Application No: WA/93/21/PL  
Site Address: Land adjacent to Oak Bank Wandleys Lane Walberton BN18 0QR  
Description of works: New detached dwelling & detached garage. This site is in CIL Zone 3 & is CIL Liable as new dwelling. This application is a departure from the Development Plan.

Planning Application WA/93/21/PL, Land adjacent to Oak Bank Wandleys Lane Walberton BN18 0QR  
Walberton Parish Council wishes to object to this application. We have a number of concerns:

Ground Floor Plan

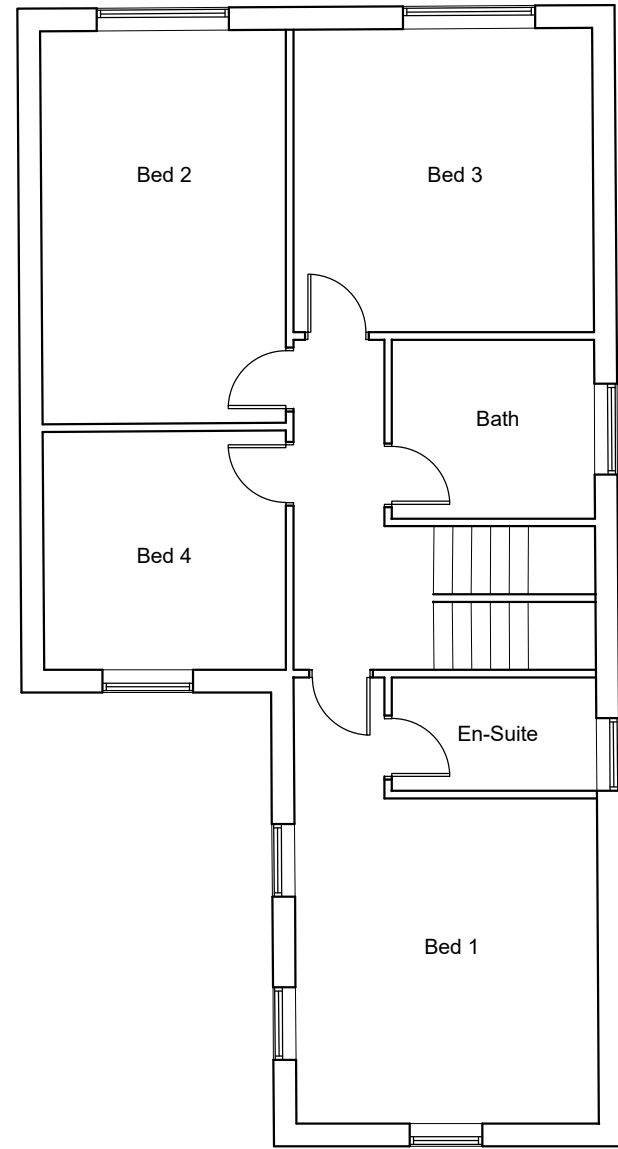
We note that the pre-application recommendation is that one section of the dwelling by the site boundary be single storey.

Garage Plan

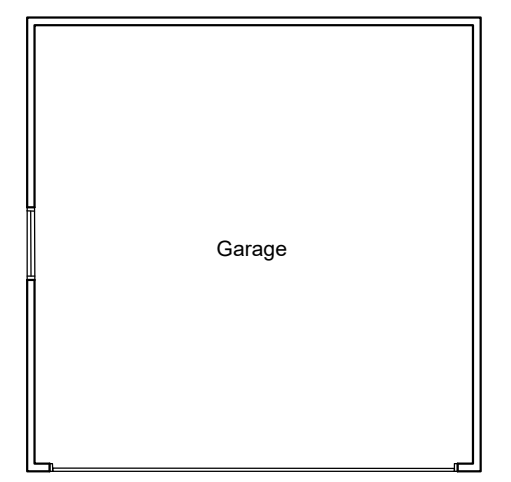
The proposed double-bay garage is smaller than the recommended size for this type of structure as stated in the Manual for Streets.
